RE: ACCESSIBILITY STATEMENT AT S4.55 MODIFICATION - LANDSCAPE DESIGN STAGE FOR SYDNEY MODERN – ART GALLERY OF NSW EXPANSION PROJECT (SSD 6471)

The purpose of this submission is to advise that we have undertaken a preliminary disability access design assessment of the proposed landscape design changes, as identified in the design documentation for the development, prepared by McGregor Coxall as listed in Appendix A.

Sheet No.
LD_DA_00-02

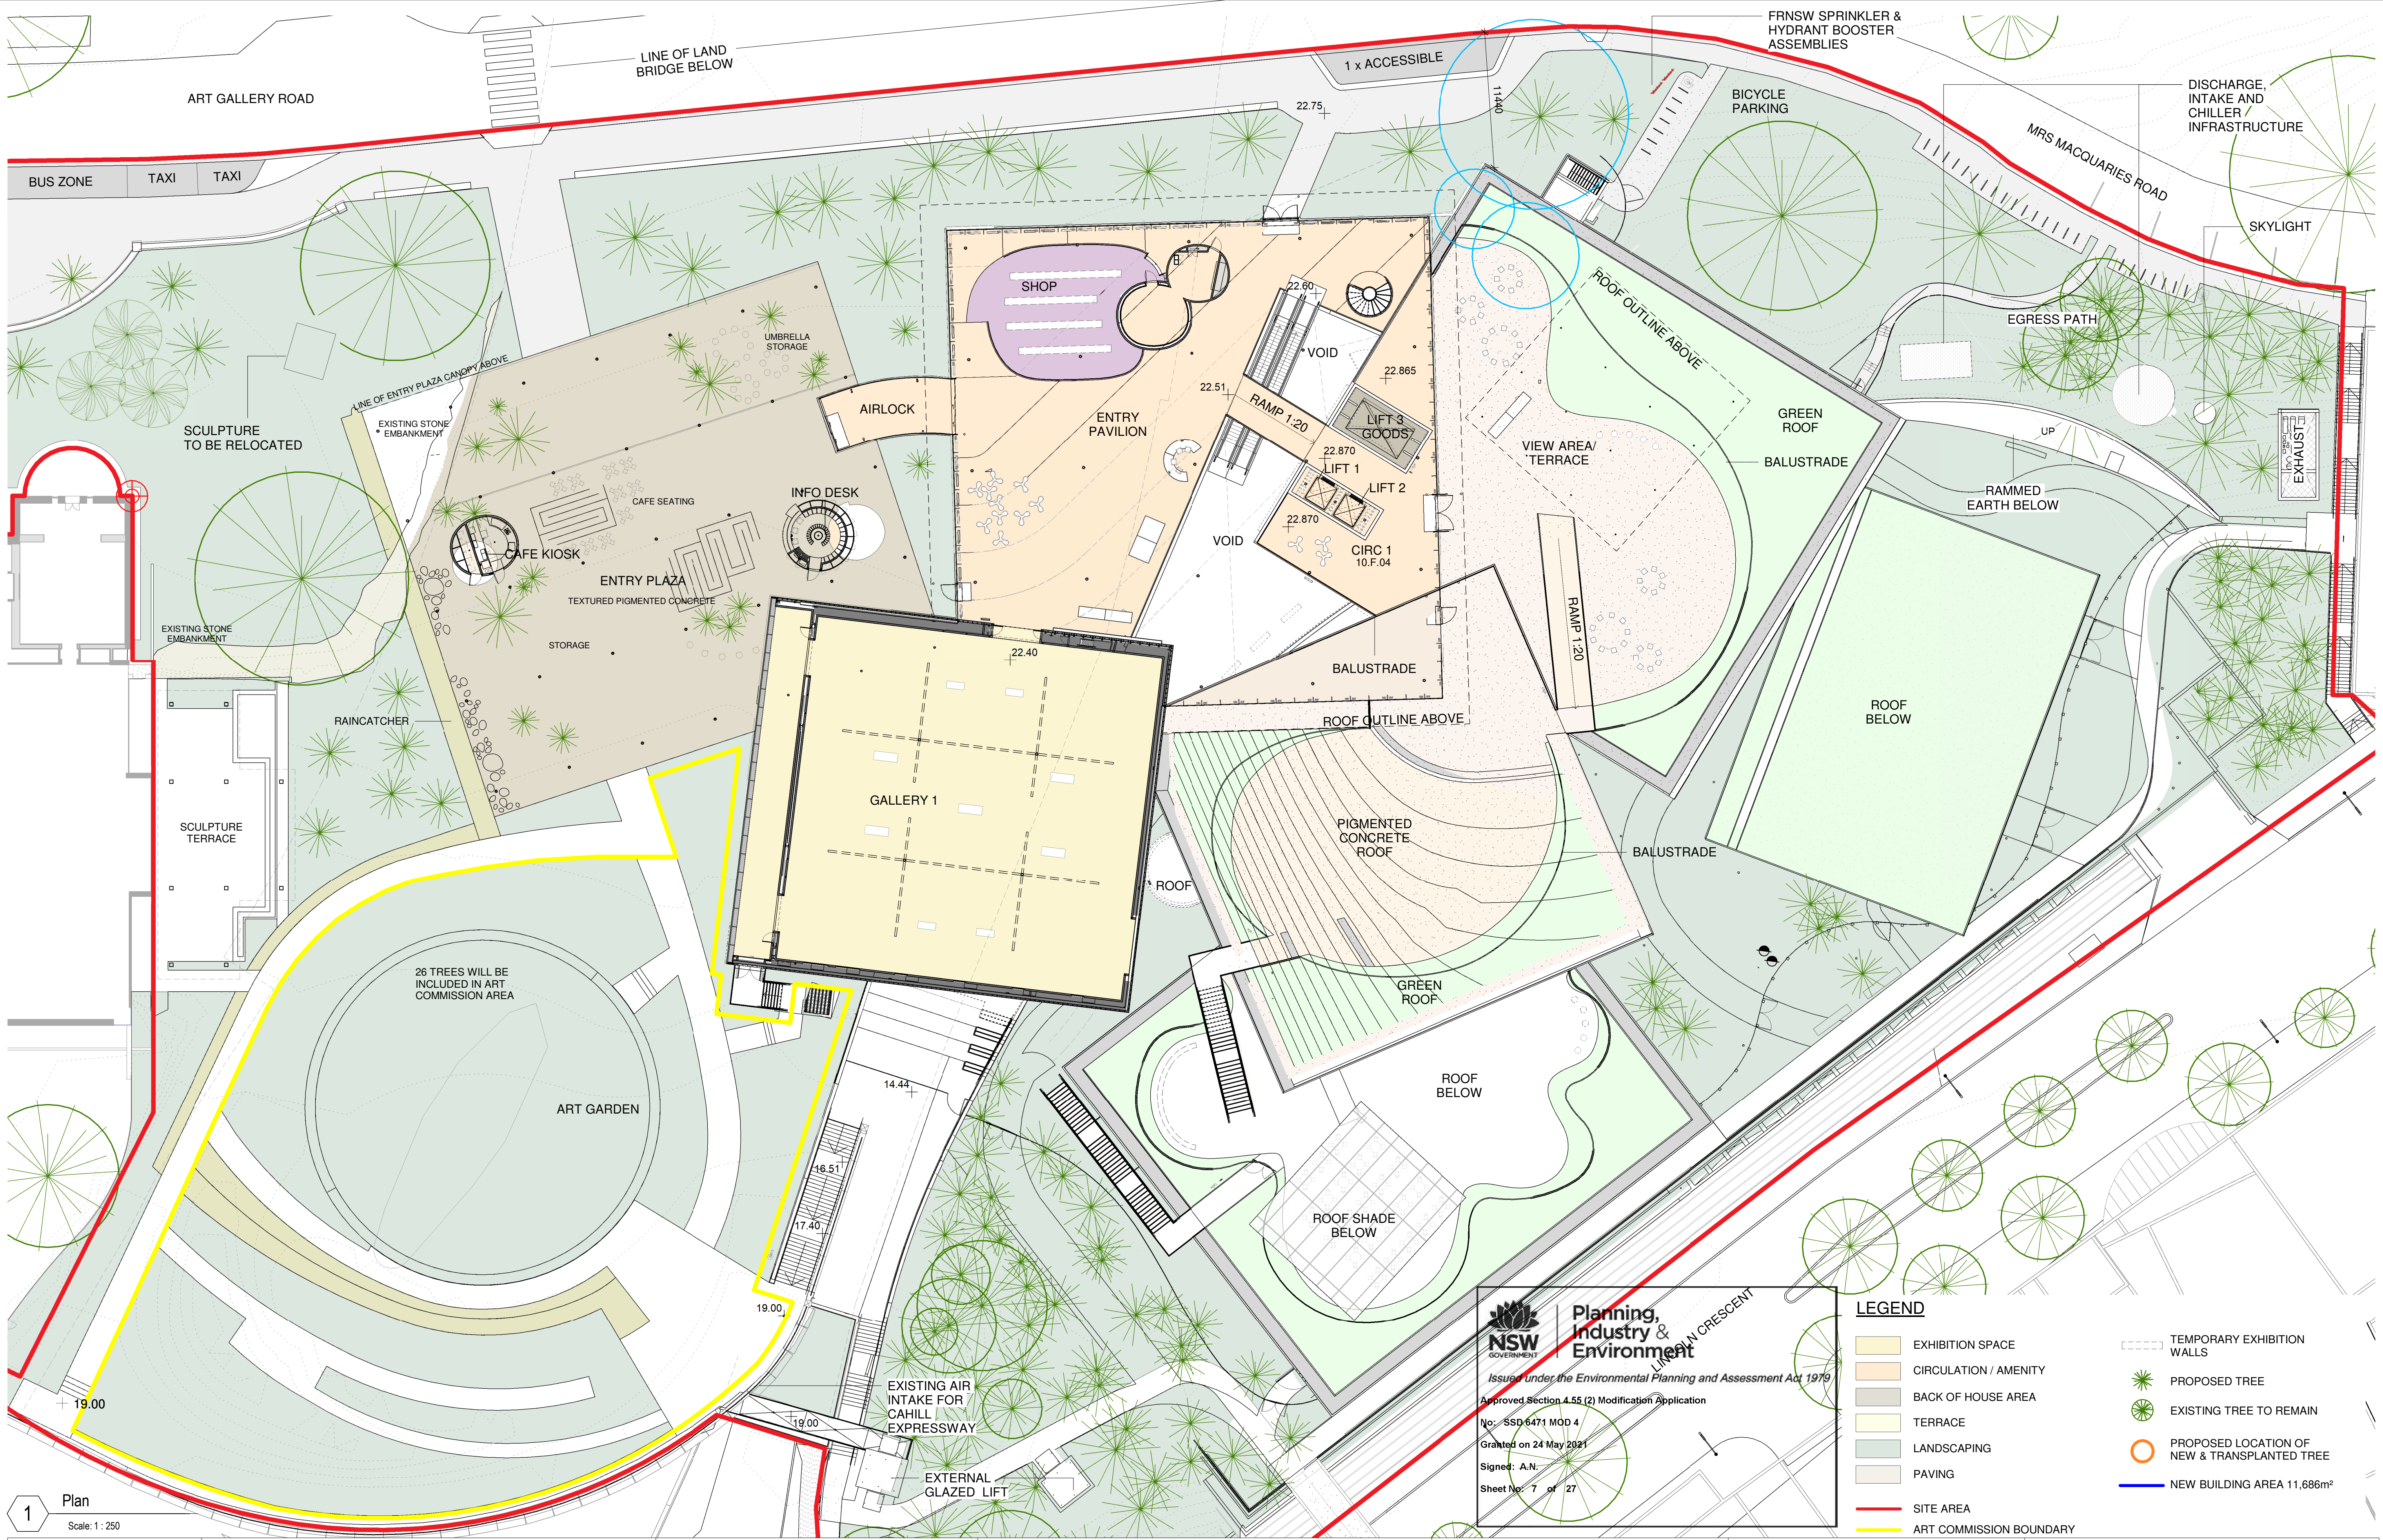
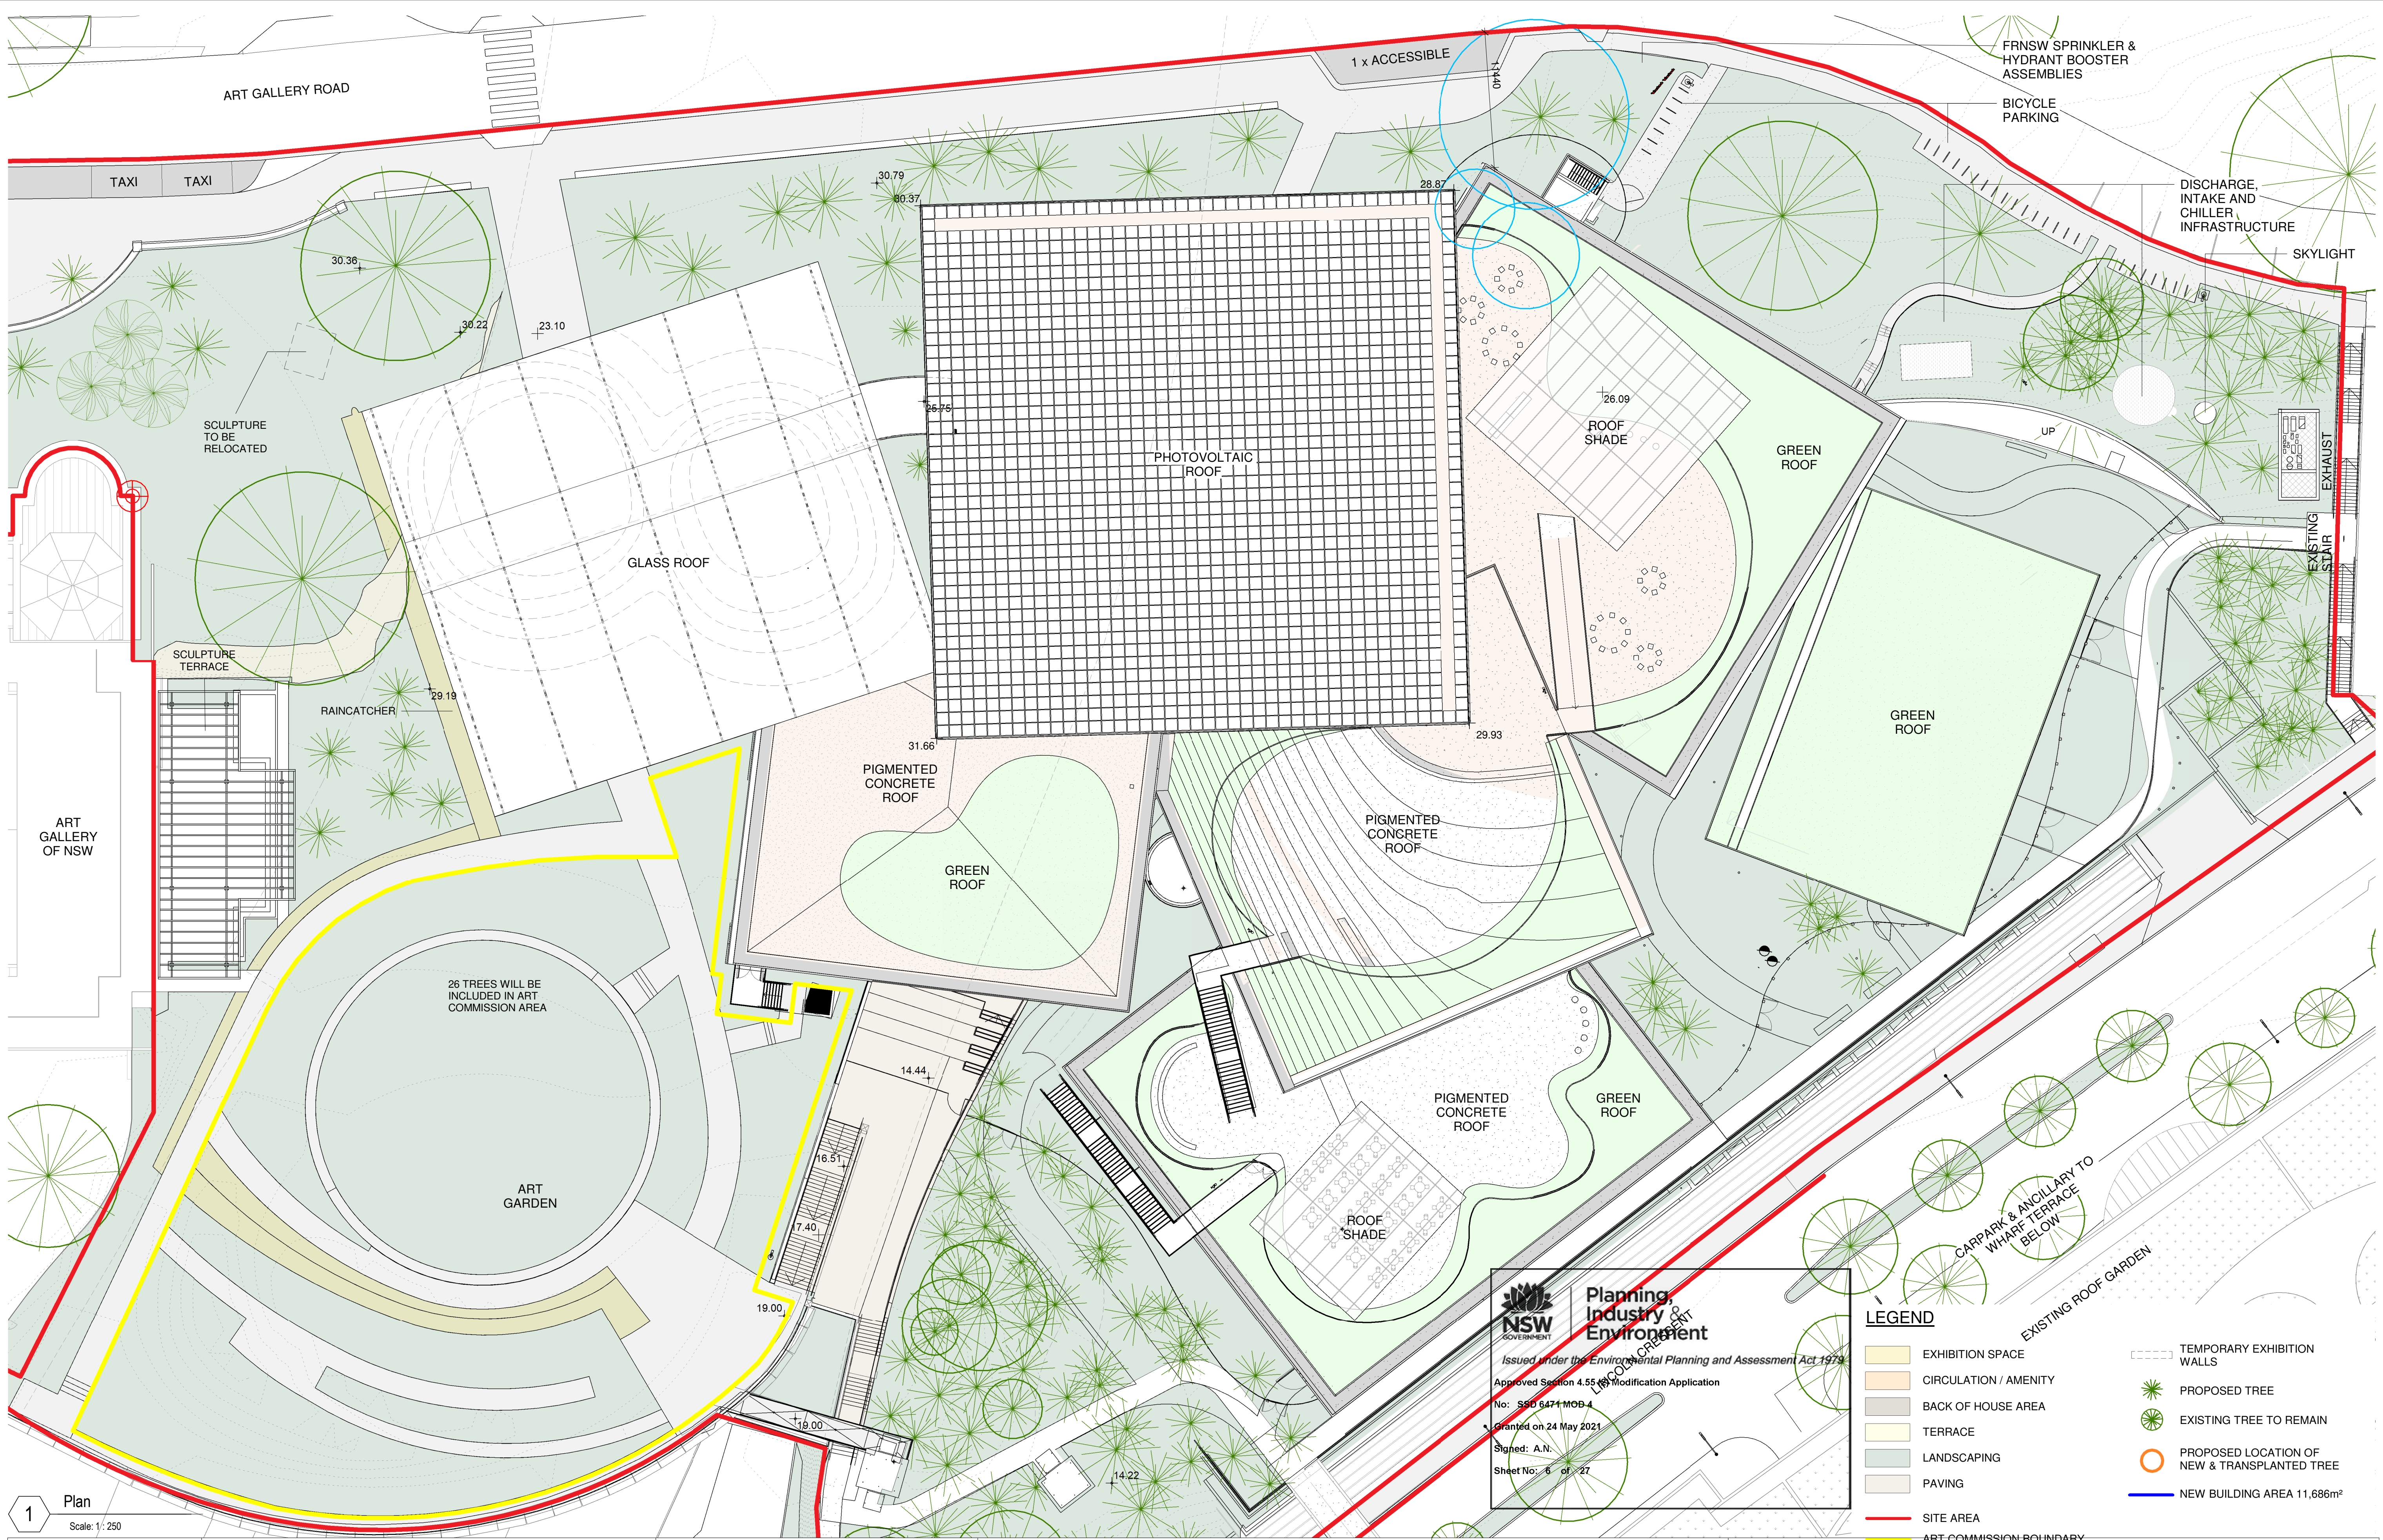
- Ensuring suitable access and safety provisions are made for people with mobility and vision impairment at footpath areas with blended kerbs, flush roadway pedestrian crossing areas and bollards in compliance with AS1428.1 and AS1428.4.1;
- Providing a kerb ramp at the rear of the taxi/vehicular set-down area to ensure continuous access for people using wheelchairs and mobility aids from the roadway to footpath, compliant with AS1428.1 and AS2890.6;
- The developed design of the bus stop/s is to be in accordance with the Disability Transport Standards (DSAPT) requirements including 150mm min. height kerb at bus boarding point (for deployment/use of bus access ramps) and TGSI provision in compliance with AS1428.4.1.

- Ensuring walkway gradients that are no steeper than 1:20 gradient with appropriately sized landing areas and minimal cross-fall (not steeper than 1:40) in compliance with AS1428.1 for compliant external access to the new building and associated facilities and services. *Note: The landscape design interface to the new building is critical to meet BCA Part D3.2 requirements and to ensure a compliant, accessible through site-linkage to Woolloomooloo.*

- Ensuring curved walkways have 1500mm min. clear width (1800mm width preferred), with suitable edge protection/delineation developed in compliance with AS1428.1;
- Developing stair details with access features, in compliance with AS1428.1 and AS1428.4.1 and consideration of safety by design for the feature stair geometry, near Gallery 1. *Note: Ergonomic Consultant input/advice is recommended for stair tread and riser dimensions.*
